**RE: SSD 8593 – Proposed expansion of an existing resource recovery facility  
No.16 Kerr Road, INGLEBURN**

Thank you for referring the response to submissions to Campbelltown City Council for comment. The following comments are provided to assist the Department with its assessment.

VEHICLE TURNING PATH
TRUCK & DOG: C & D TIP & SPREAD

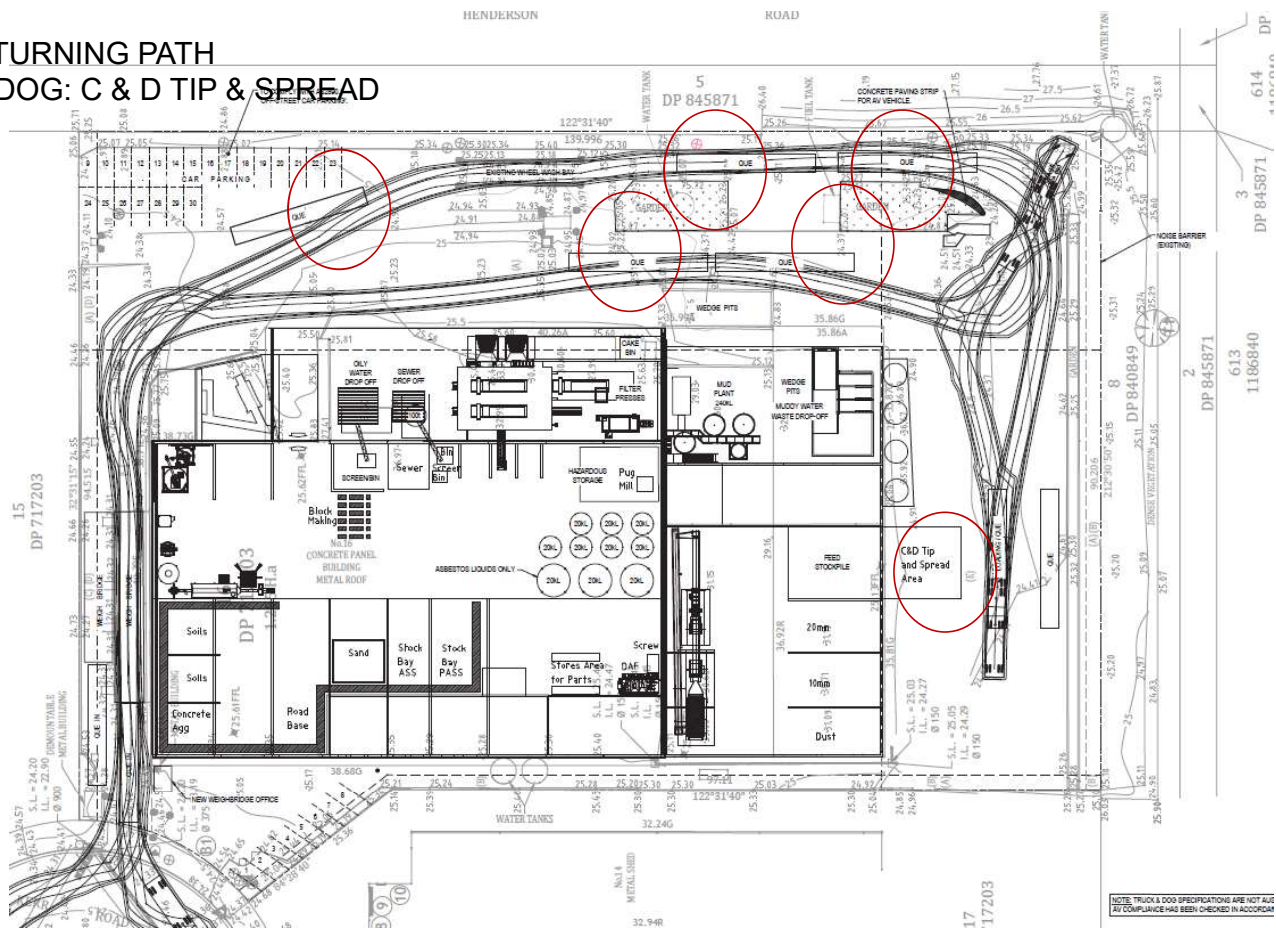
In addition, the swept path diagrams submitted show that manoeuvring on site is very tight especially the Vehicle Turning Path truck and dog: C & D Tip and Spread plan which shows that the existing acoustic wall interferes with manoeuvring of trucks as they come through the wheel wash bay to the rear of the site.
